Please ask for: Ms Iqraa Malik
Email: iqraa.malik@terraquest.co.uk
Telephone: 01212341390
Our Ref: M/51/20/HH
Your Ref:
Date: 17th July 2020

Application for Planning Permission for Works or Extension to a Dwelling

Development: Single storey side extension with flat roof
Location: 53 Ilex Way Middleton-On-Sea PO22 6PN

TITLE:
Existing & Proposed Plans

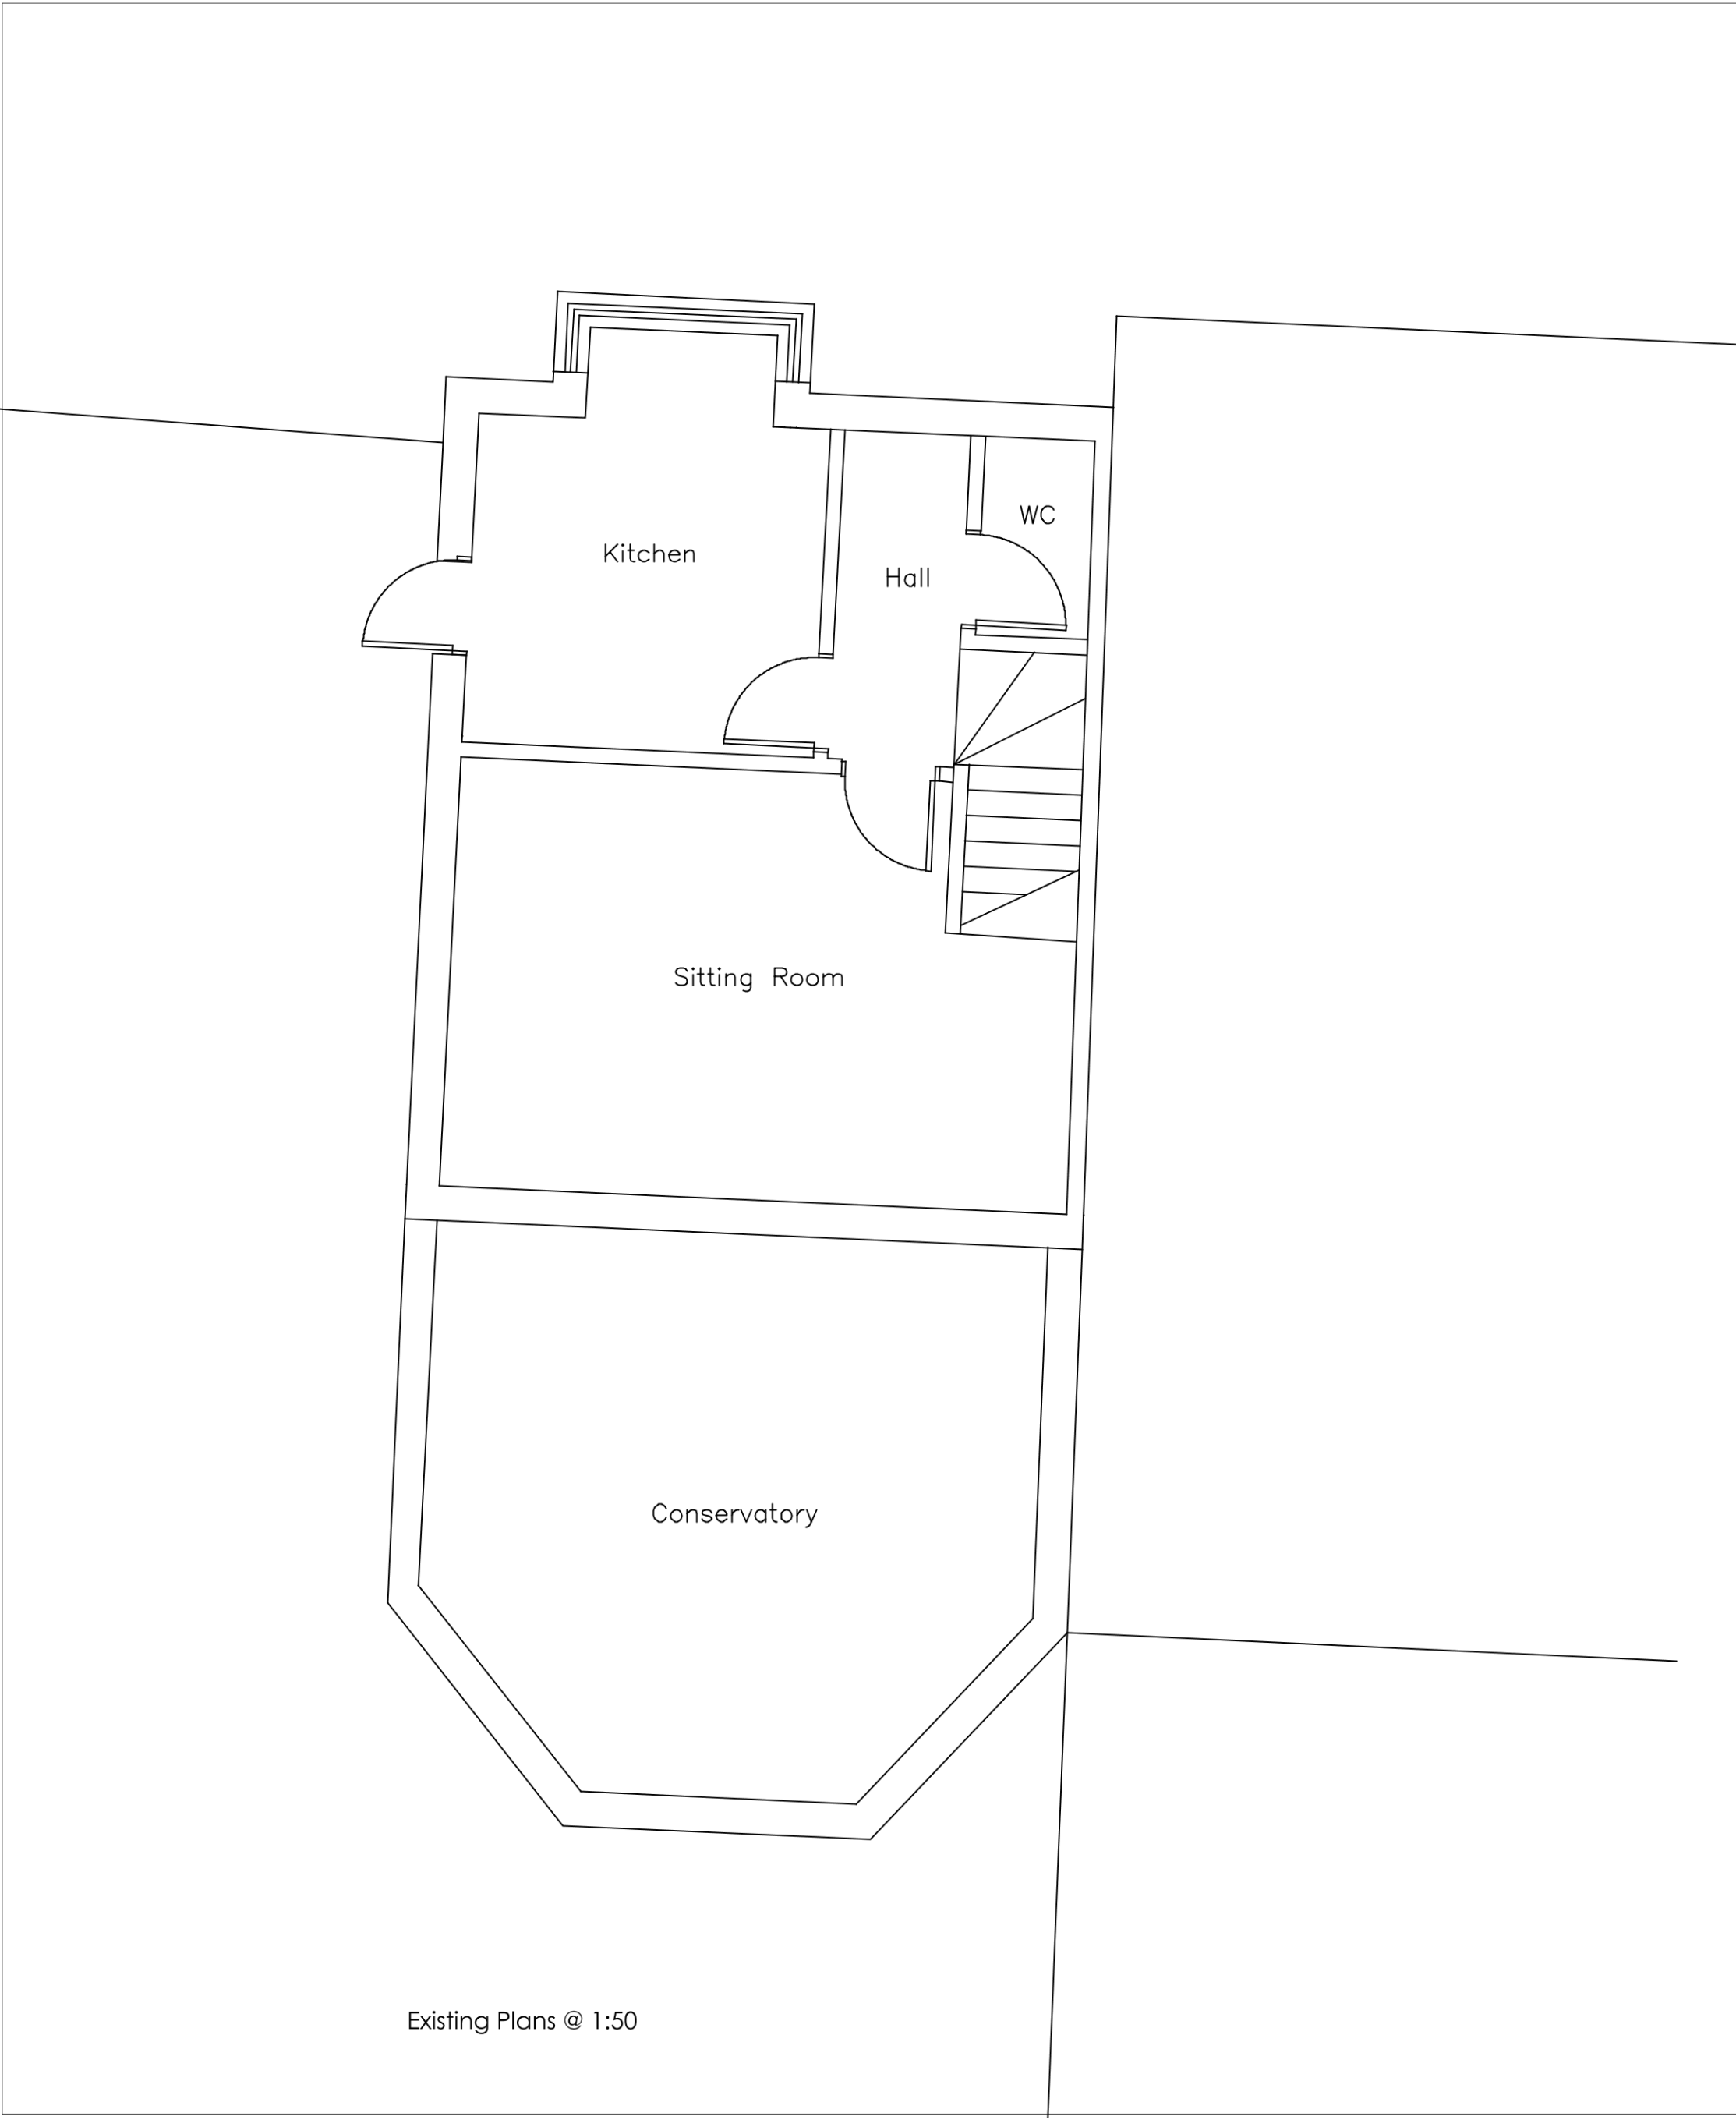
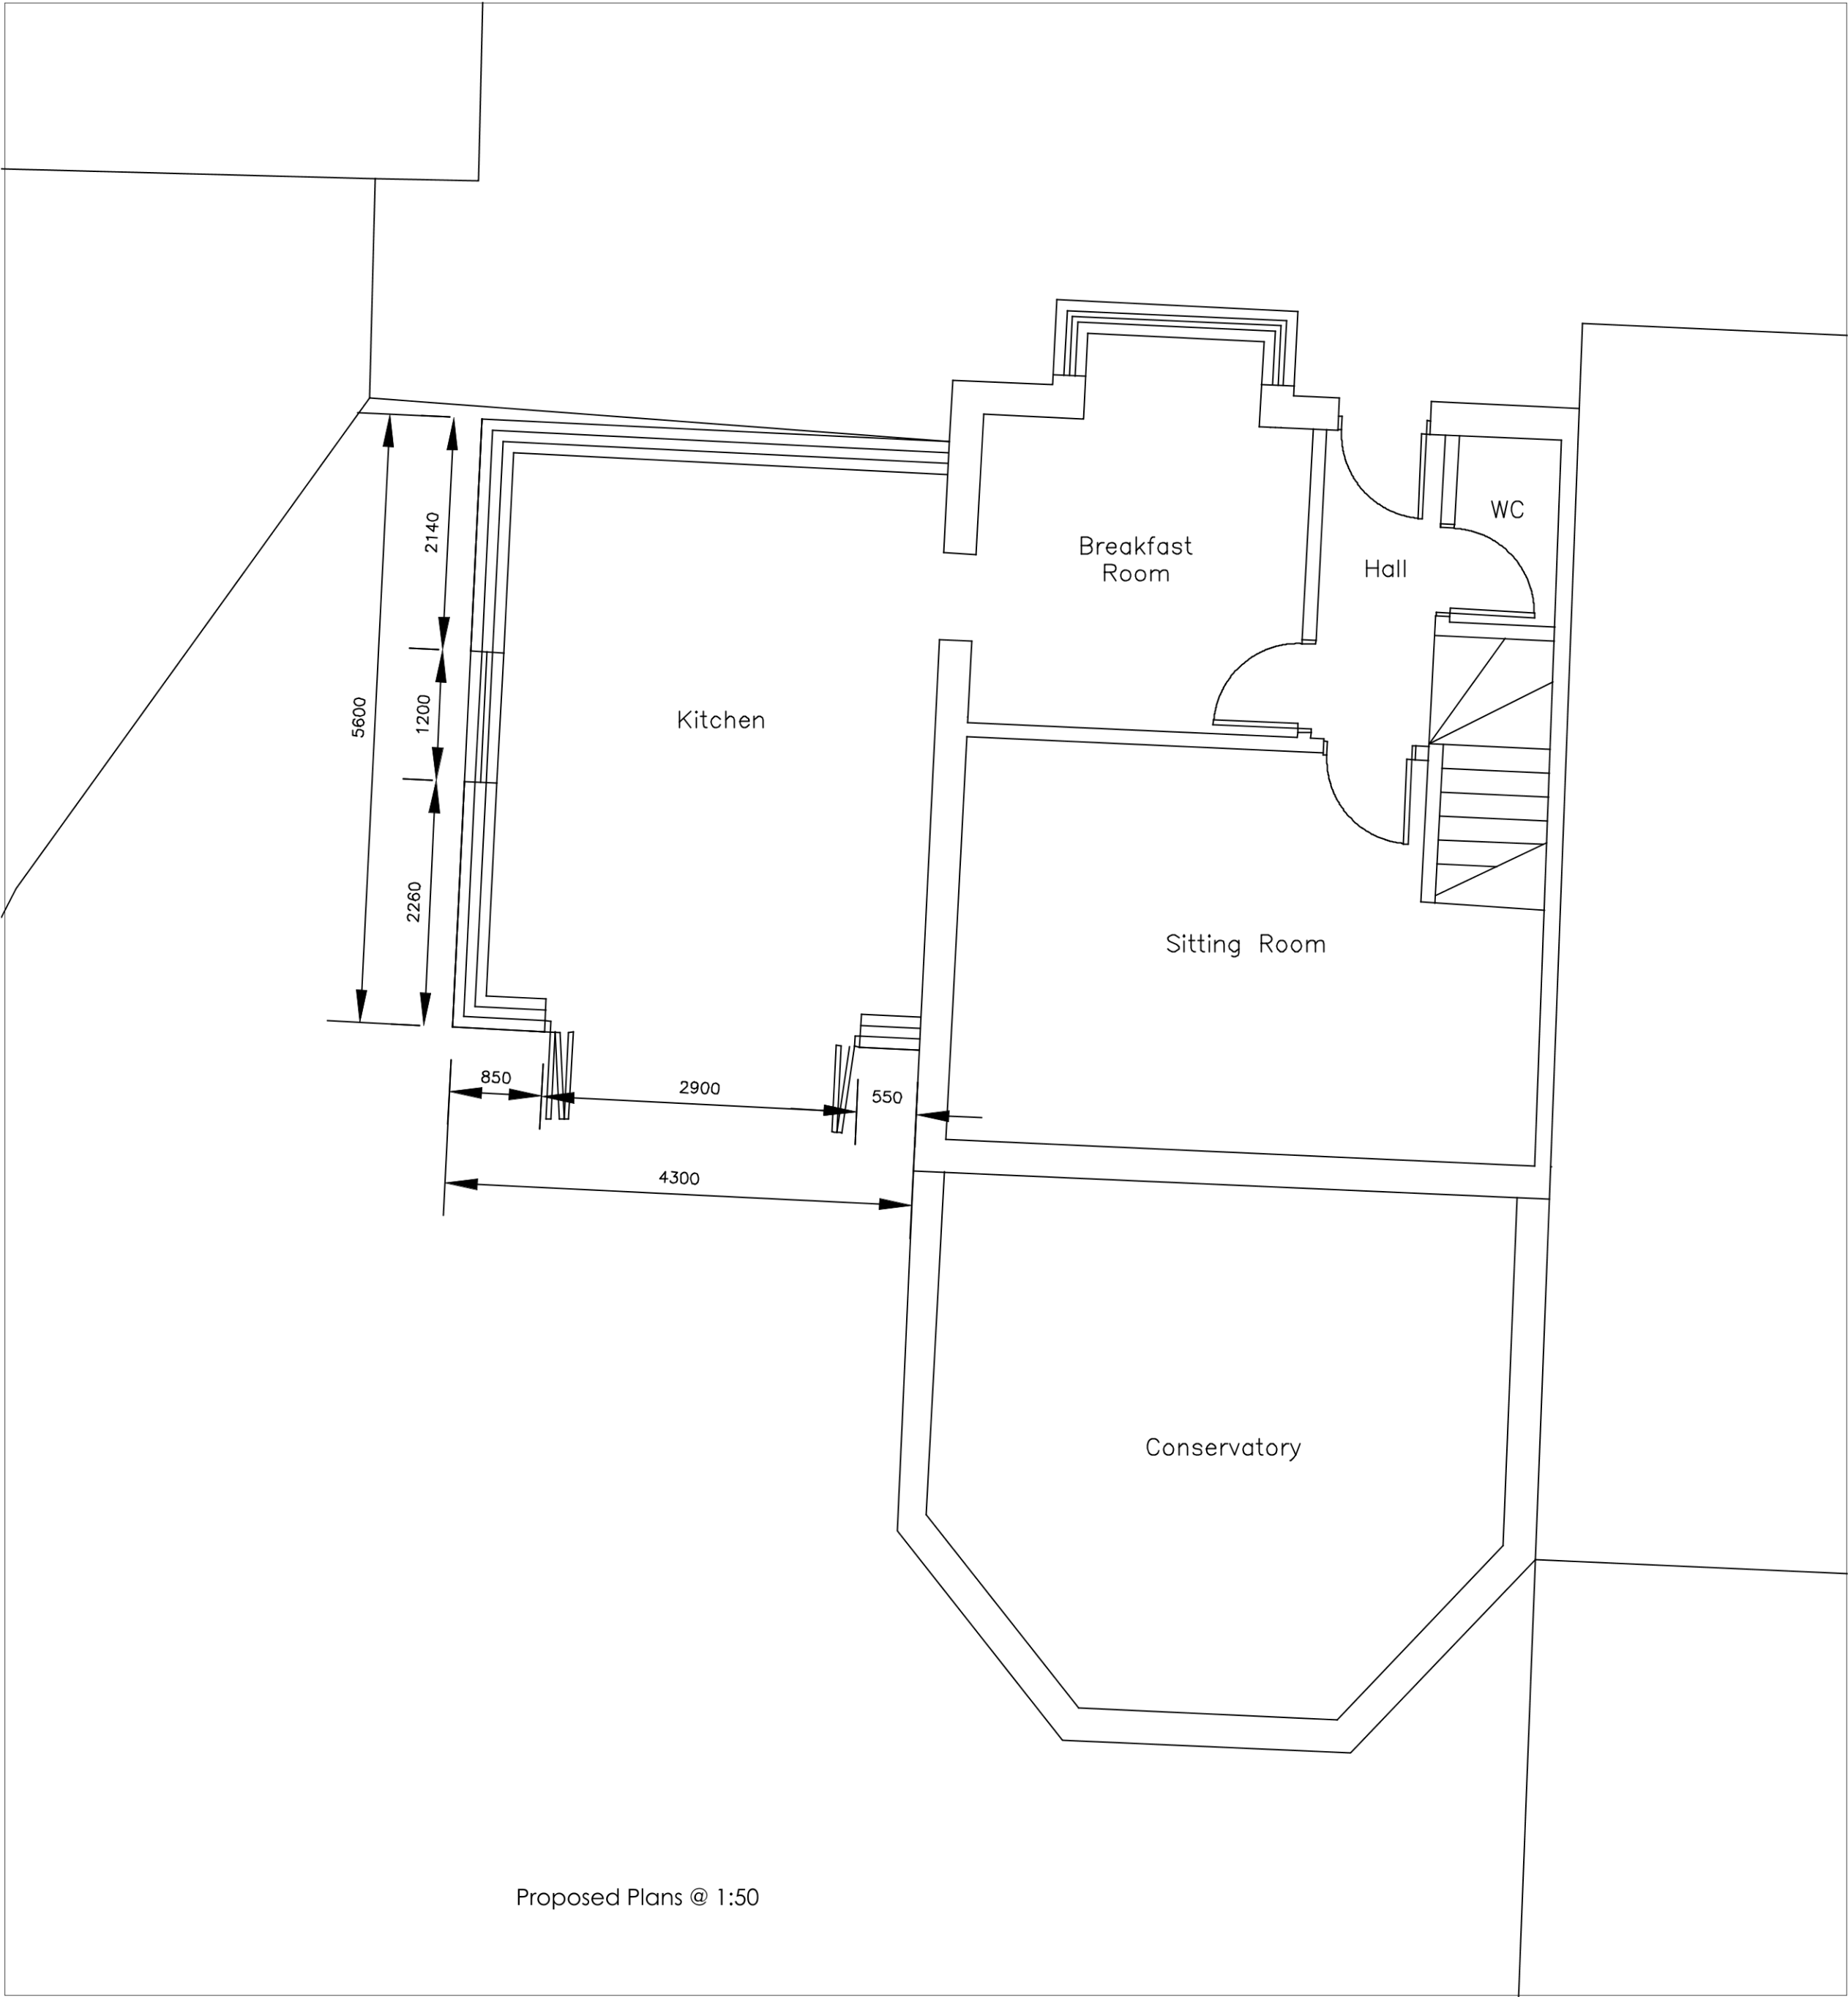
Floor Plans

The proposed ground floor plan dimensions are not to scale. Please amend.

All Plans

All plans require a scale bar. Please amend.

Block Plan 1:500

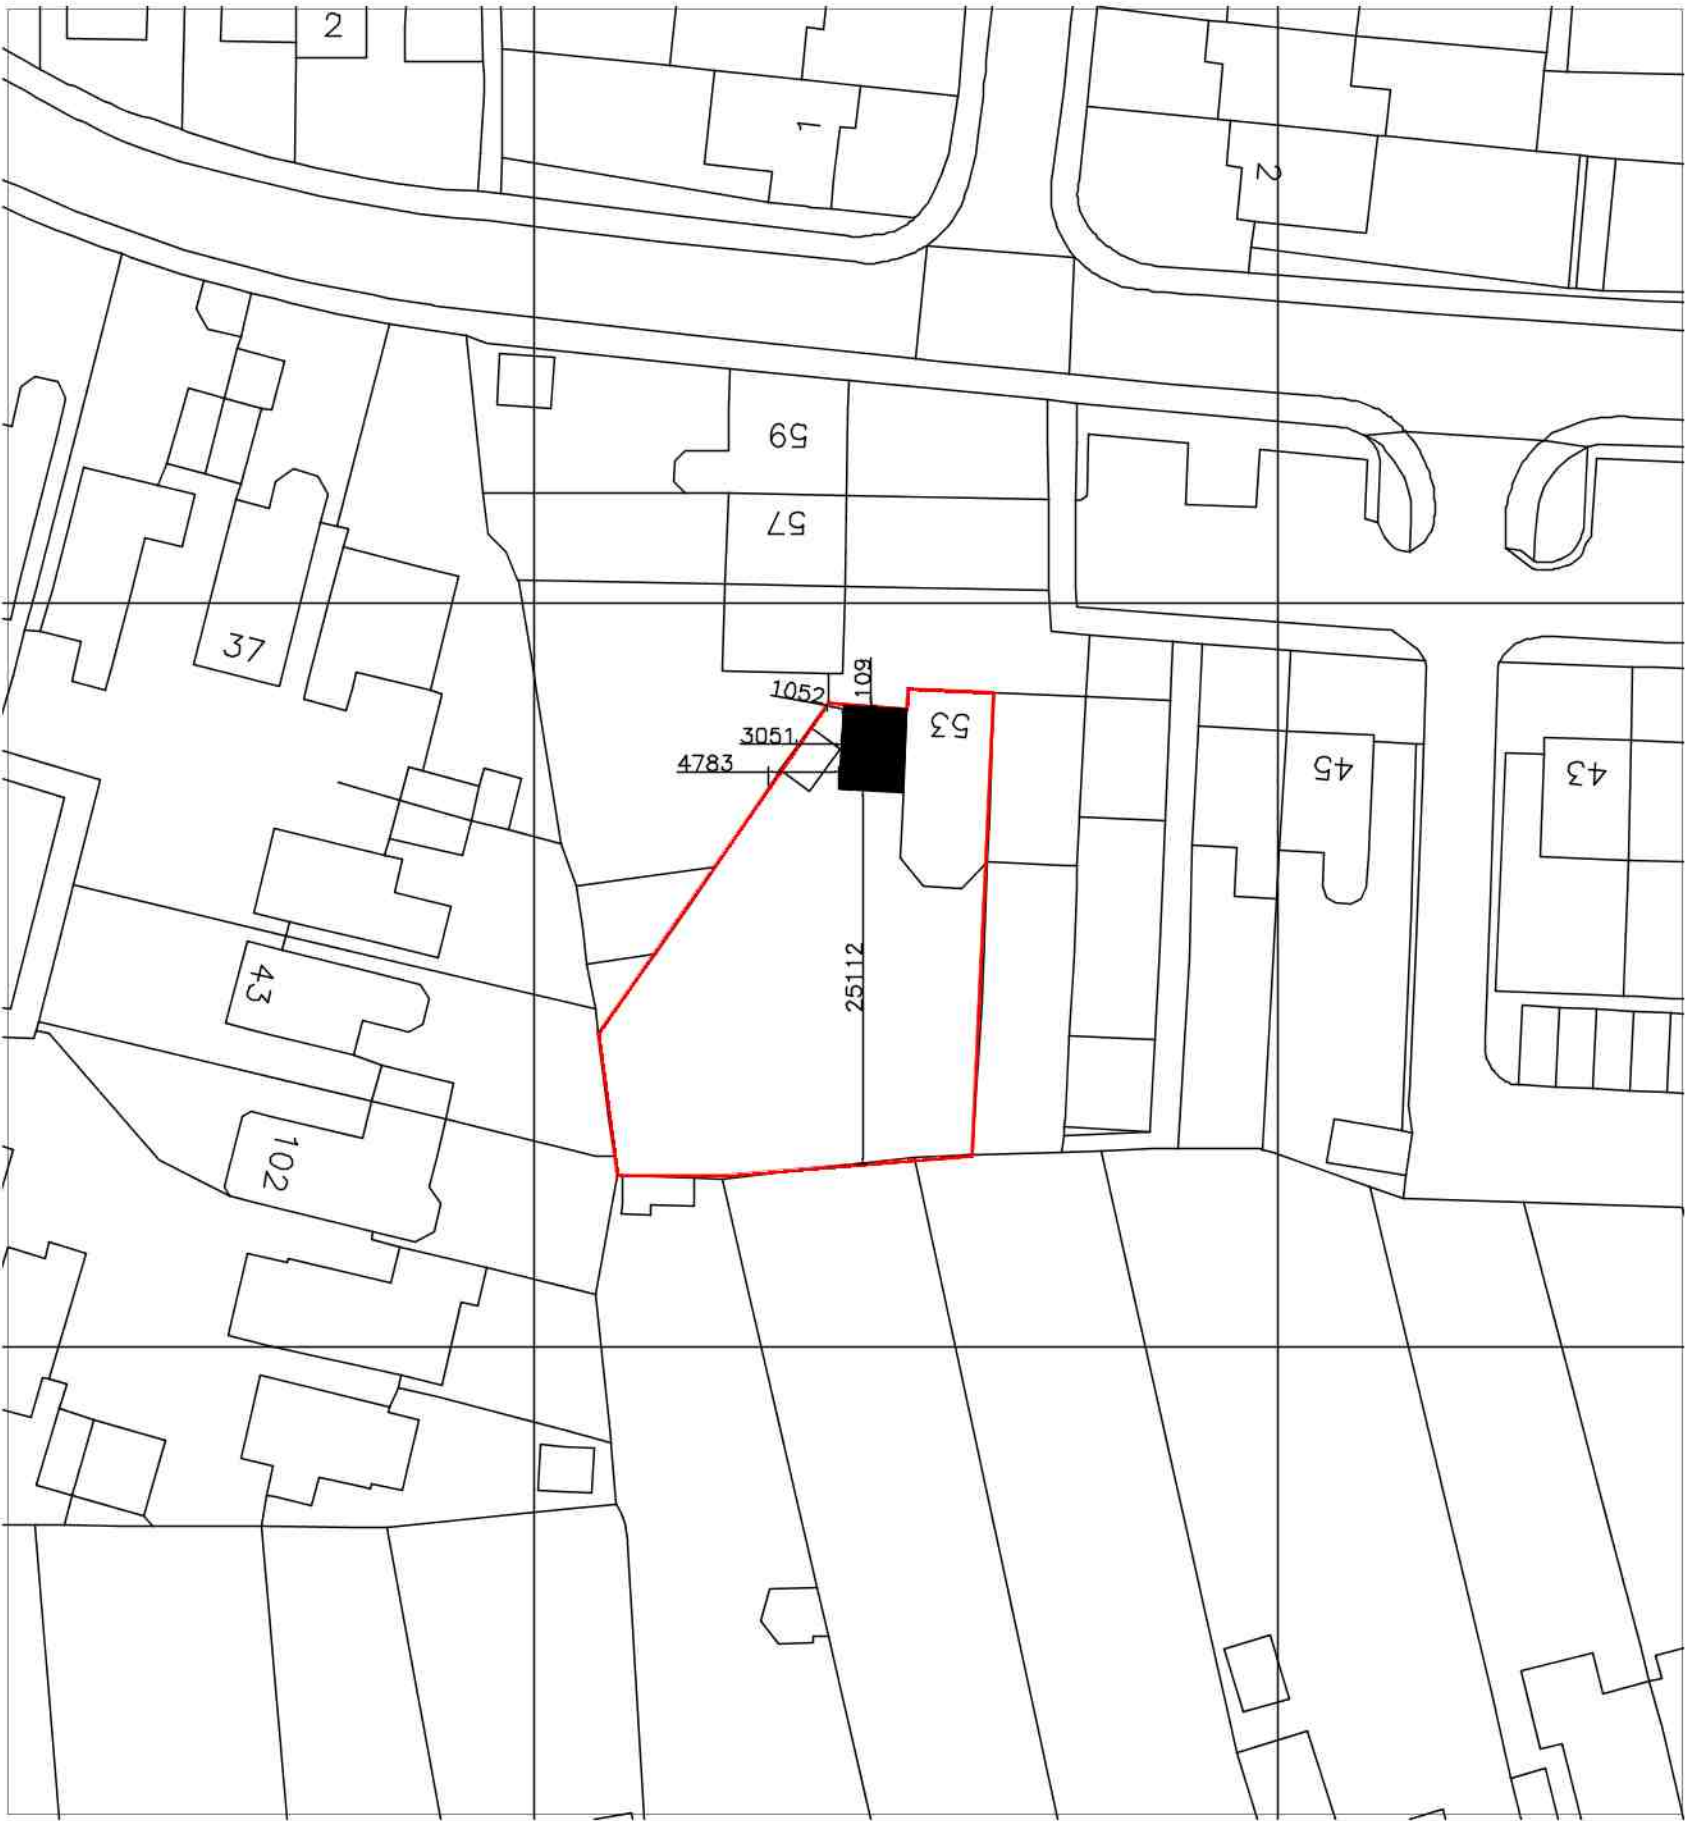
Block Plan

You are required to have dimensions from the proposed extension(s) to all site boundaries. Please amend.
